Recommendation Report for Planning Permission

REF NO: BR/201/20/PL

LOCATION: 29 Highcroft Crescent
Bognor Regis
PO22 8DH

PROPOSAL: Re-establishment of dwelling to form former pair of semi-detached bungalows (resubmission following BR/139/20/PL).

Proposed

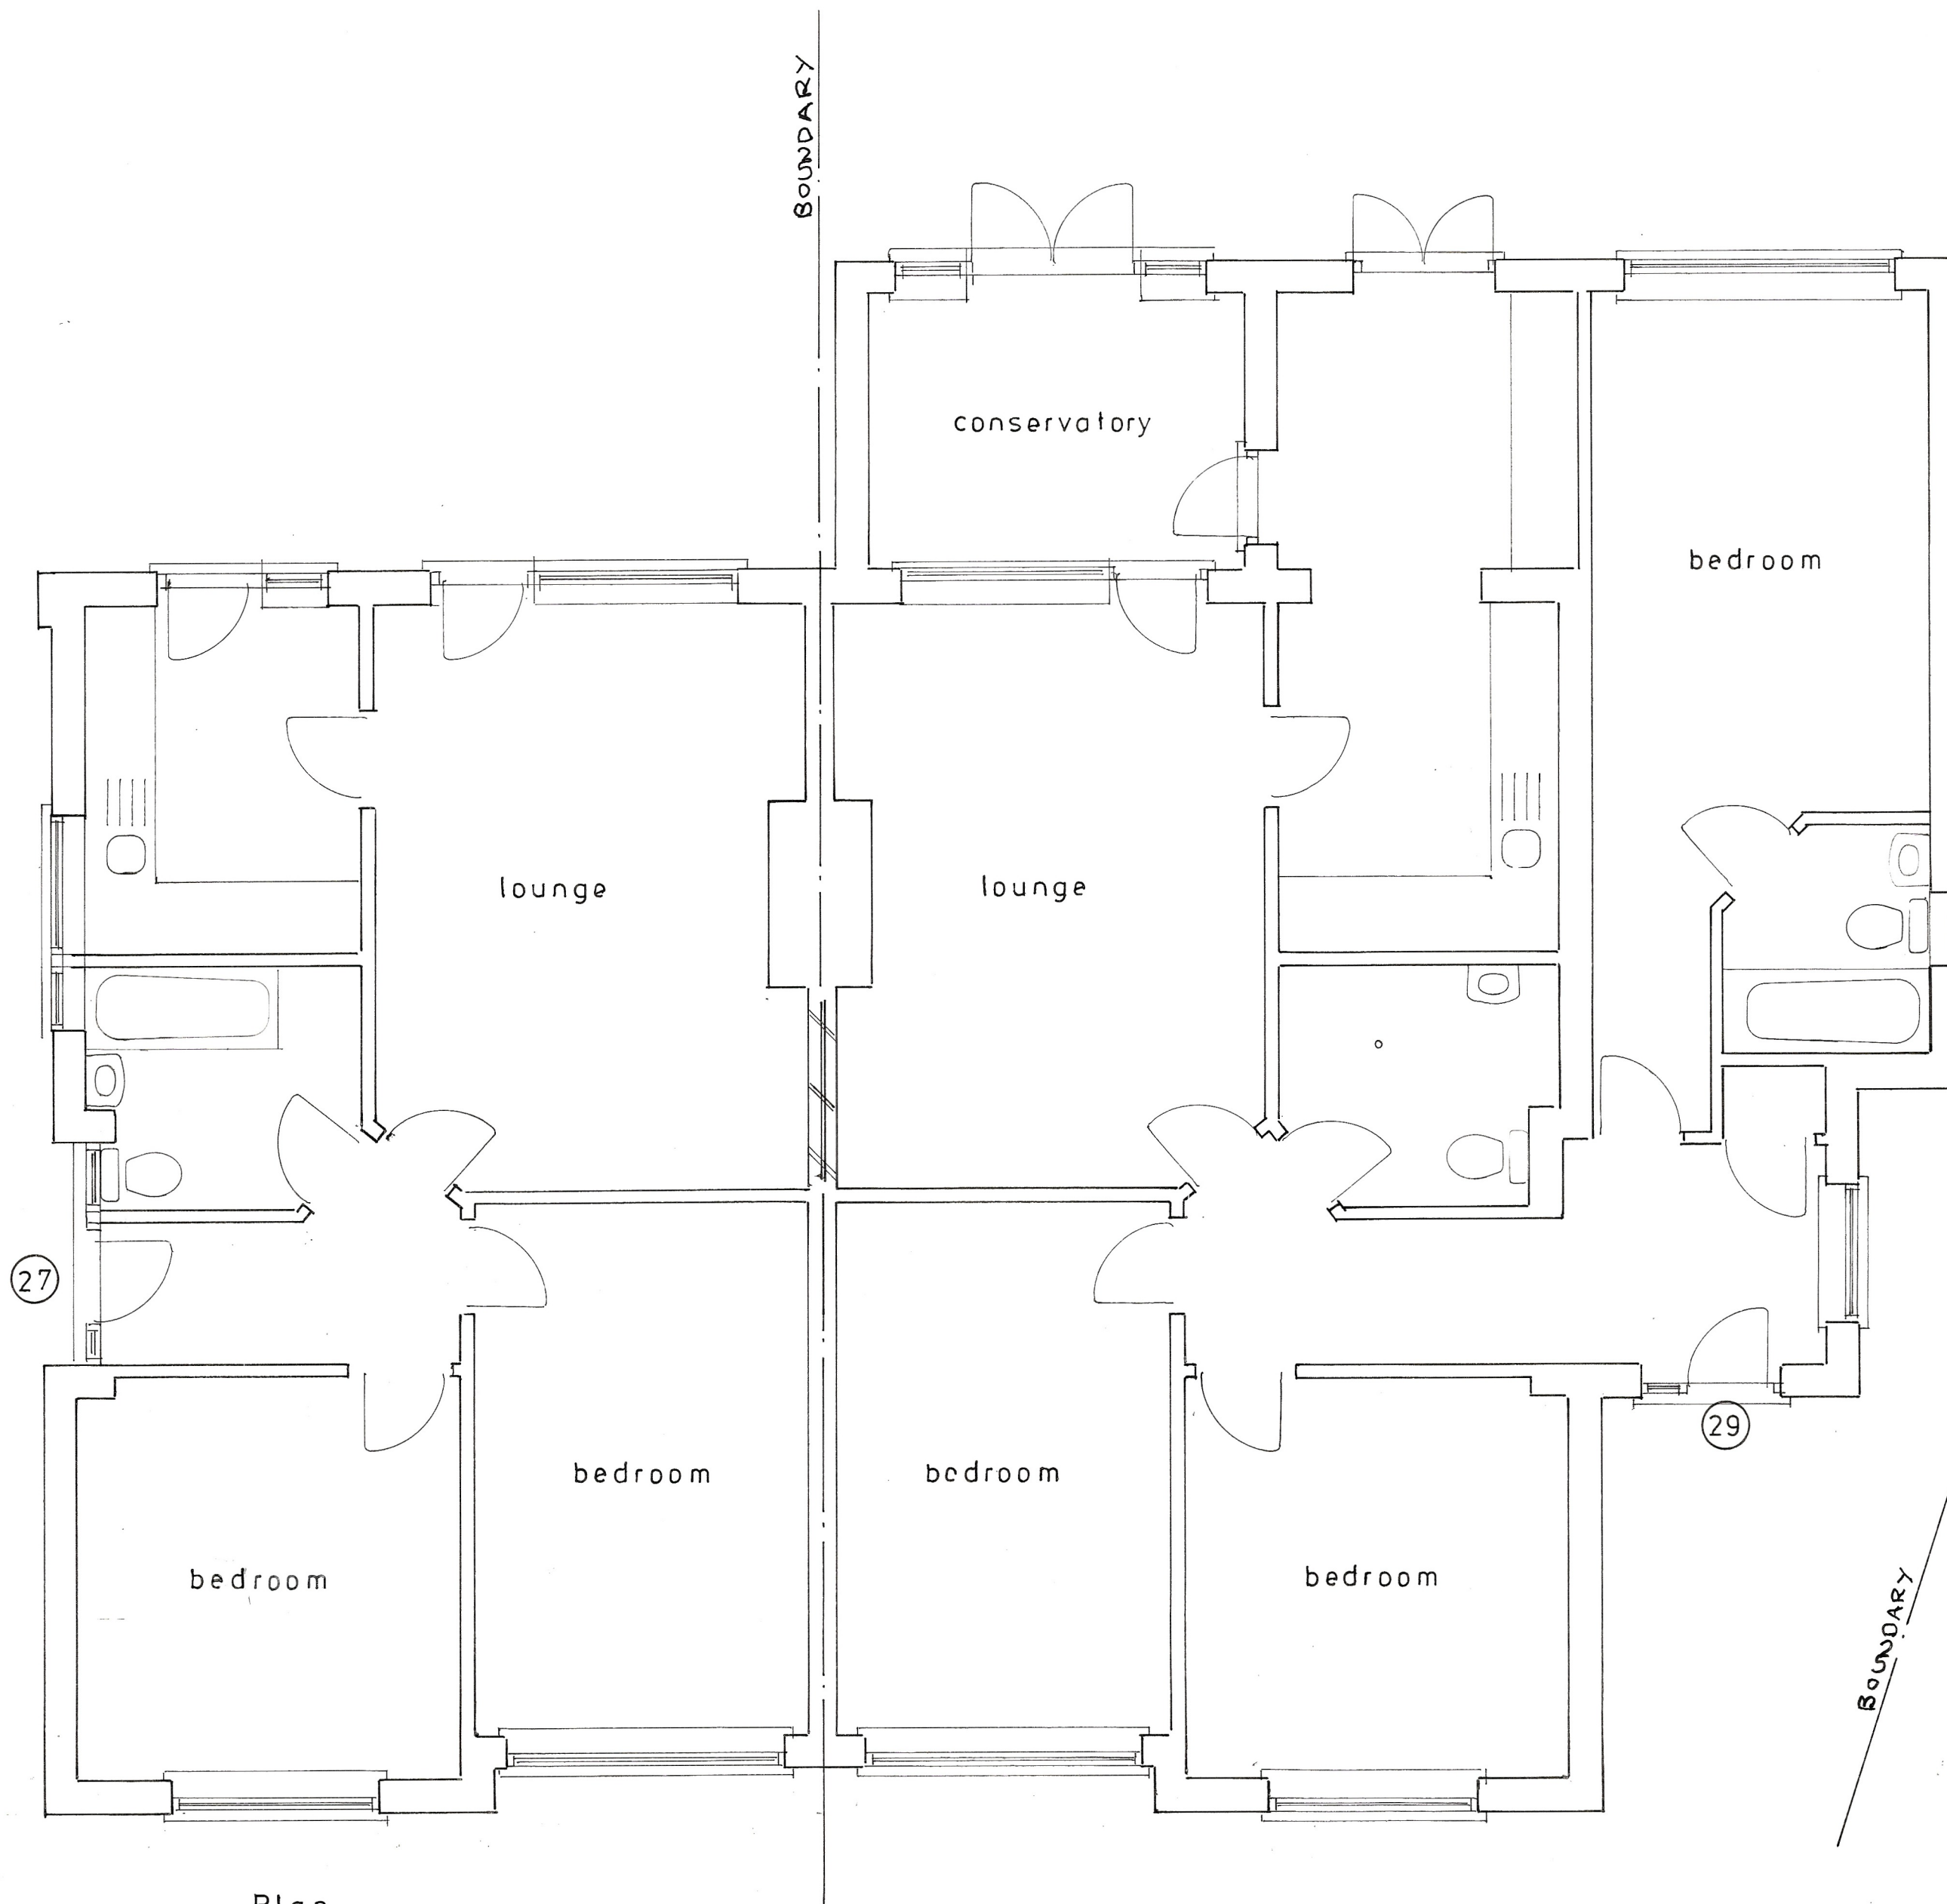
The 2 bed bungalow has a Gross Internal Area (GIA) of approximately 63sqm. The national internal space standards (set out in the 'Technical Housing Standards - Nationally Described Space Standards') require that a 1 storey 2B4P home have a minimum GIA of 70sqm. The plans show a 2B4P home i.e. with 2 x double bedrooms shown. The 2 bed dwelling falls short of the national internal space standards by around 7sqm. Given it did before it was converted in 2014 to a single dwelling and given it does as an existing dwelling, this shortfall is considered acceptable in this case.

The 3 bed bungalow has a GIA of approximately 103sqm. The national internal space standards for a 1 storey 3B are between 74-95sqm. As such, the 3 bed dwelling would exceed the national internal space standards.

The application proposes to utilise the existing driveway for vehicular parking. ADC Parking Standards SPD require a minimum of 1 on-site car parking space to serve a 2 bed dwelling and 2 on-site car parking spaces to serve a 3 bed dwelling in this type of location (Parking Behaviour Zone 4) so a total of 3 spaces on site. WSCC confirmed an inspection of the plans shows there appears to be sufficient space in the driveway for 3 car parking spaces to be accommodated.

Flood Risk Assessment for 27/29, Highcroft Crescent, Bognor Regis.

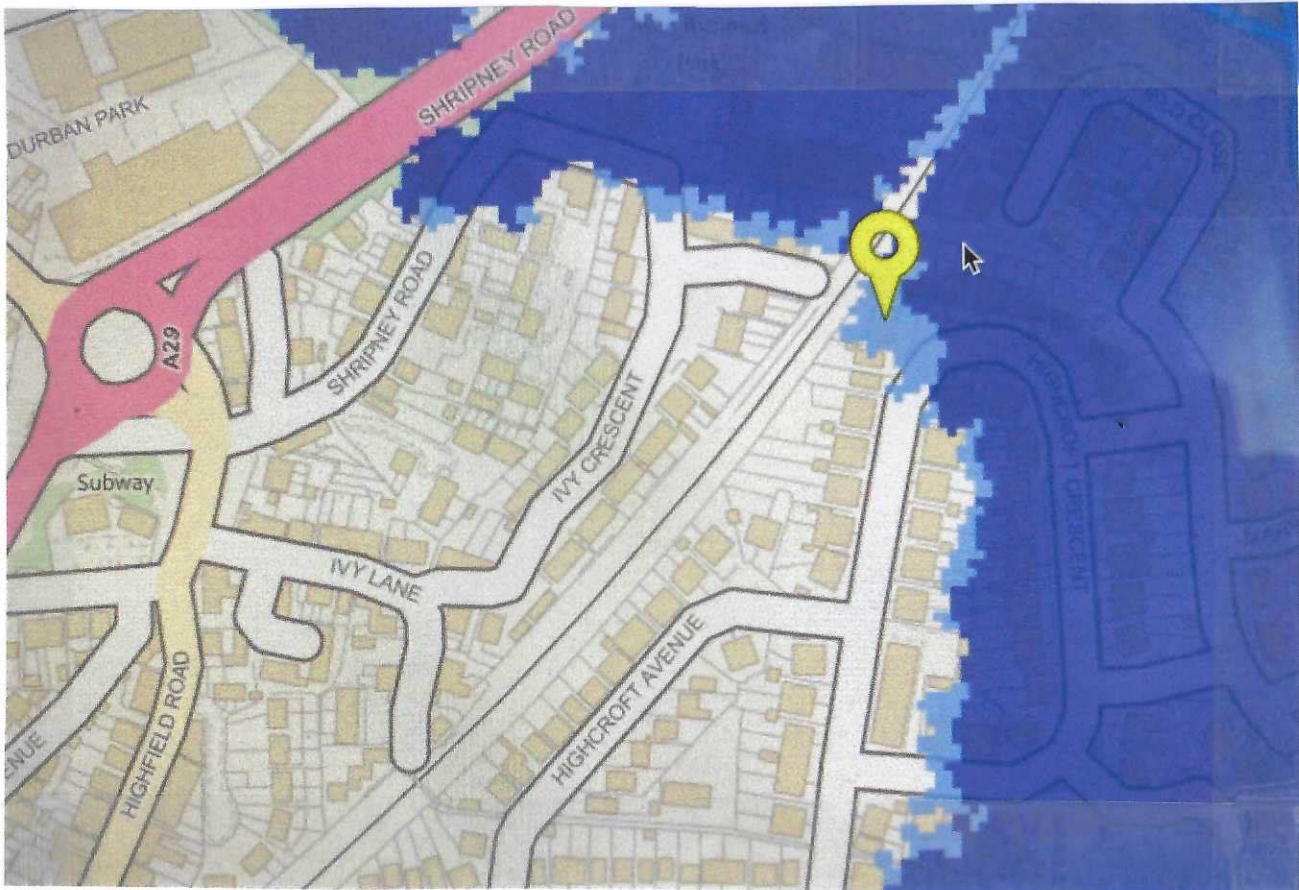
Although a Flood Risk Assessment has been supplied a sufficient and robust Sequential Test and Exception Test has not been supplied. As such, it is considered that insufficient information has been submitted to demonstrate that the application site is sequentially preferable and consequently the proposal is considered to be contrary to ALP W DM2 and the National Planning Policy Framework, specifically the section 'Meeting the challenge of climate change, flooding and coastal change.'

Due to the lack of a Sequential Test and Exception Test having been applied and submitted, the proposals fail to accord with the NPPF and ALP Policy W DM2 with regard to flooding and drainage.
